File no: SSD 9368; MC-19-00004.

**Re: SSD9368 - Farmland Drive SCHOFIELDS – Alex Avenue Public School**

## ATTACHMENT A

C04.03

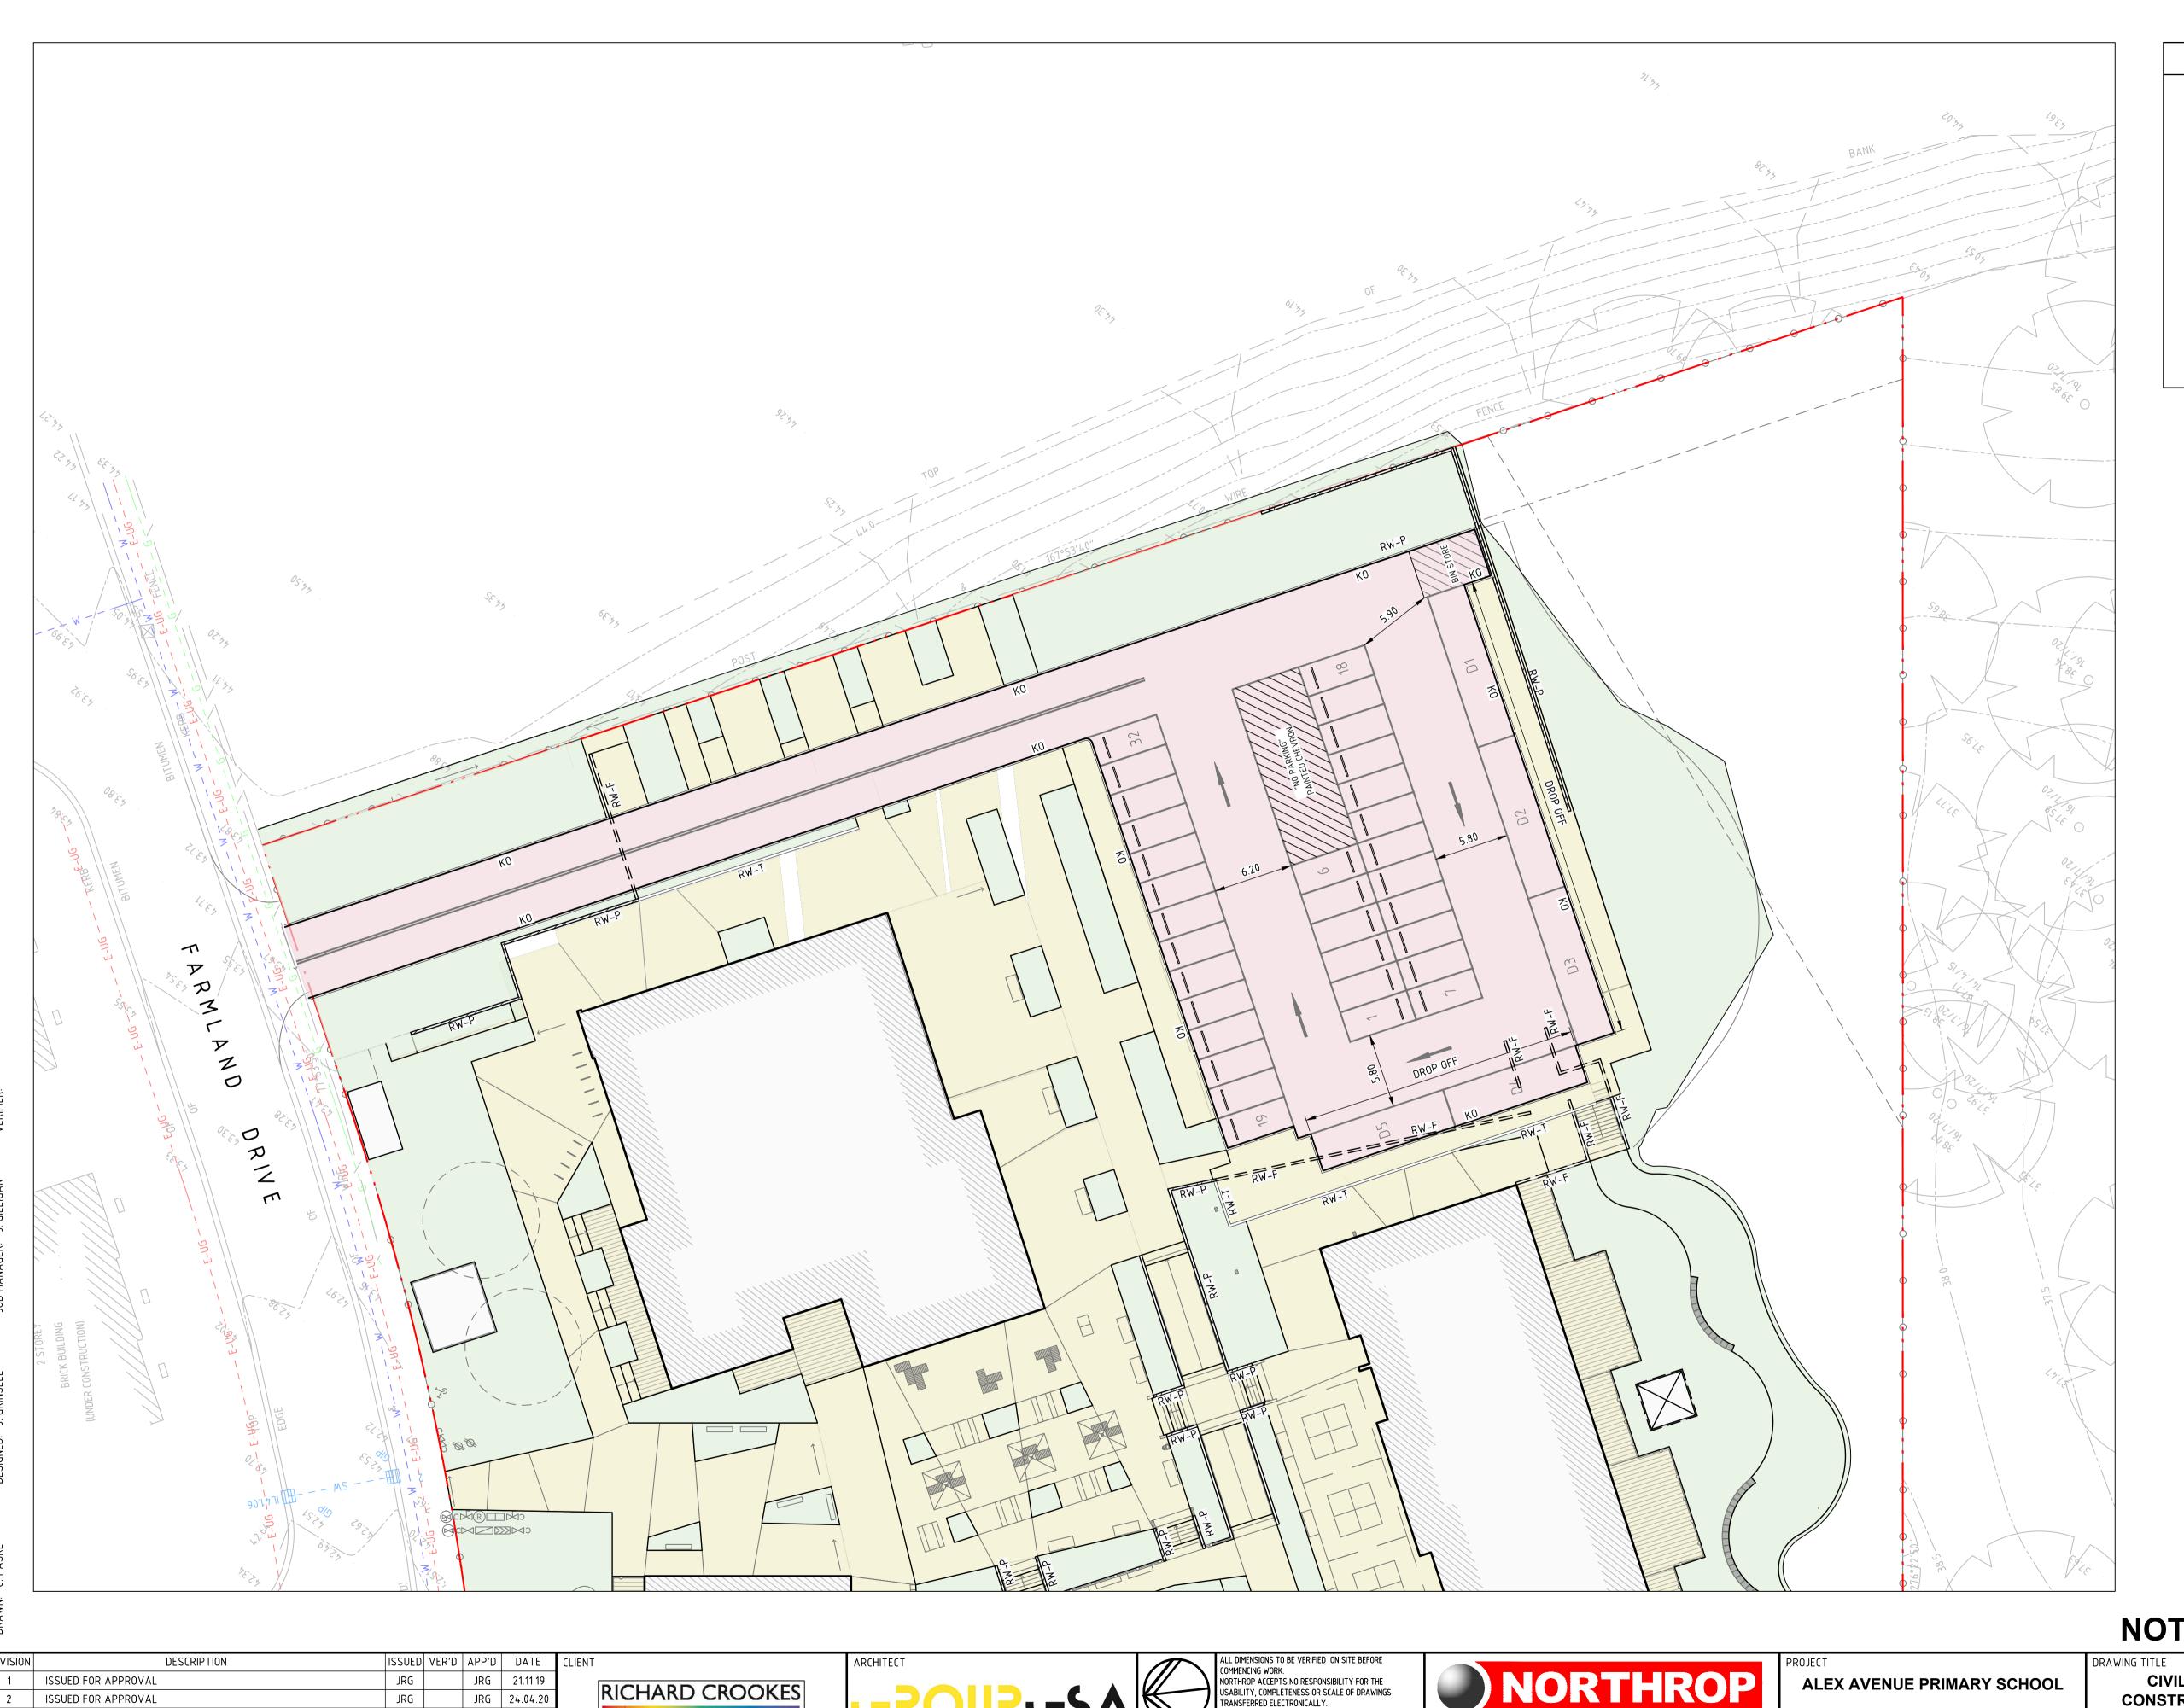
- a. The Media Filter, Transition and Drainage layer materials to comply with Plan No. A(BS)175M. Annotate these on the drawings.
  - b. Increase filter media depth to 500mm. Provide minimum 450mm transition layer and 200mm drainage layer.
  - c. Provide at least 2 cross-sections at right angles to each other.
  - d. Provide a cross-section through inlet pipe with levels.
  - e. Provide a cross-section through overflow pit with levels.
  - f. The bio-retention system shall be modelled as a submerged system as per Plan No. A(BS) 175M.
  - g. Provide inlet pits rather than a headwall to the bioretention. Refer to sheet 7 of the WSUD standard drawings.
16. The rip rap scour protection is shown in detailed drawings (Section A of C04.03) but not shown on the plan. Also Dwg. No. C04.03 does not exist.
  17. Provide an electronic version of MUSIC model.

22. Rename all pits on the long sections to match plan pit numbers i.e. 1/4 on plans should match the 1/4 on the long section, currently they do not.
23. Pit 1/9 is called for in the drainage long section yet not provided on the plan.

24. On all the long section, provide the HGL design storm in addition of the 100 and 2 year HGL.
25. Pit 4/2 in Dwg. No. DAC04.22 does not have adequate cover. The minimum cover is to be 100mm below a slab.

26. The rainwater tank incorrectly shows the roof drainage line connecting to both an outlet pit (4/1) and the rainwater tank. All roof drainage is to connect directly to the

rainwater tank with the rainwater tank having a separate overflow drainage line to the stormwater system.
